Ribble Valley Borough Council  
Council Offices  
Church Walk,  
Clitheroe  
Lancashire  
BB7 2RA

Phone: 0300 123 6780  
Email: [developeras@lancashire.gov.uk](mailto:developeras@lancashire.gov.uk)  
Your ref: 3/2025/0496  
Our ref: 3/2025/0496/HDC/KW  
Date: 15 October 2025

**Location:** 18 Hornby Road Longridge Preston PR3 3RE  
**Proposal:** Demolition of rear lean-to extension and garage. Proposed single storey side and rear extensions to form garage, wc, utility and kitchen area.  
**Grid Ref:** 360701 437563

DRAWING TITLE: PROPOSED SITE PLAN
DRAWING NUMBER: 0293 - 2000

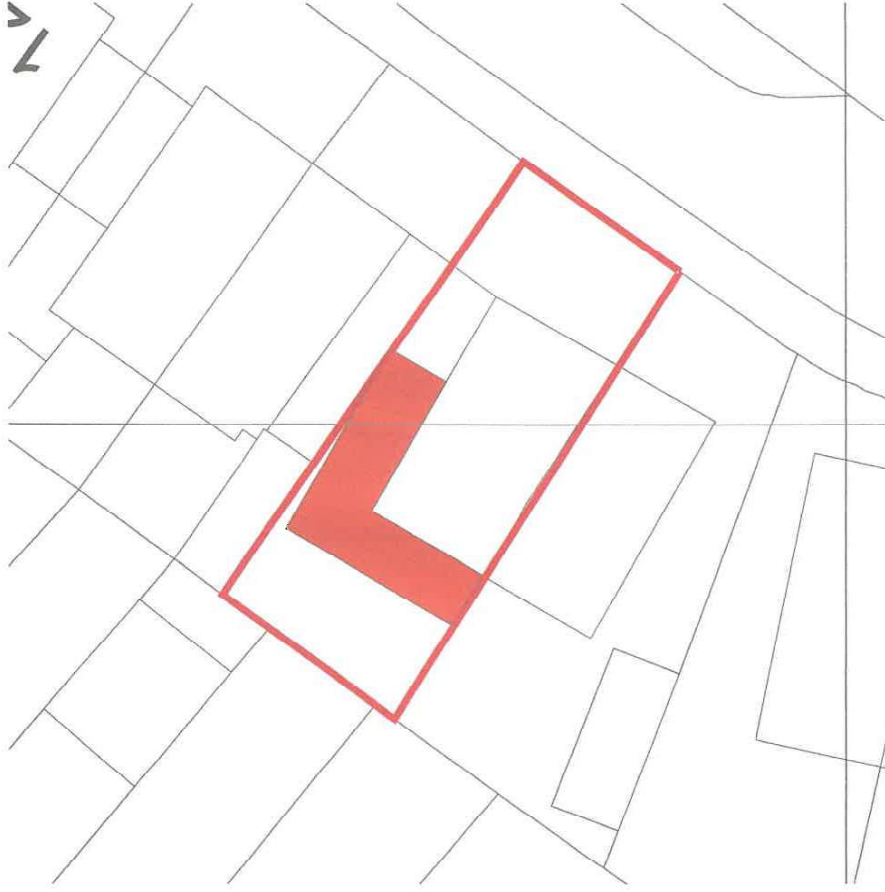
A 2-bedroom dwelling should provide at least 2 off-street parking spaces to ensure a negligible impact on highway safety and highway capacity within the immediate vicinity of the site.

The LHA has reviewed drawing 0293 - 2000 and notes that the proposal will include the extension of the existing driveway to allow for two off street parking provisions. This will require the applicant to extend the existing vehicle to support access to the extended area; an extended vehicle crossing within the adopted highway will need to be constructed under a section 171 agreement of the Highways Act 1980.

The recommended minimum internal dimensions for a new single garage is 6m in length and 3m wide. The recommended distance of 6m is based on the length of a large family car (Ford Mondeo Estate 4.58m long), clearance at the rear of the car (200mm), overhang of the garage door (600mm) and room to stand in front of the car and open/close the garage door (600mm). As the proposed garage is smaller than the recommended minimum internal dimension, it cannot be counted as a parking space.

Additionally, due to the nature of the application, it is expected that a charging point for electric vehicles shall be included in the development to promote sustainable modes of

transport. This shall be fitted in line with the DfT guidance regarding Electric Vehicle Charging in Residential and Non-residential buildings, which states charge points must have a minimum power rating output of 7kW and be fitted with a universal socket that can charge all types of electric vehicles.

1. Before the widened parking area is used for vehicular purposes, it shall be appropriately paved in tarmacadam, concrete, block paviments, or other hard material to be approved by the Local Planning Authority. Reason: To prevent loose surface material from being carried on to the public highway thus causing a potential source of danger to road users.
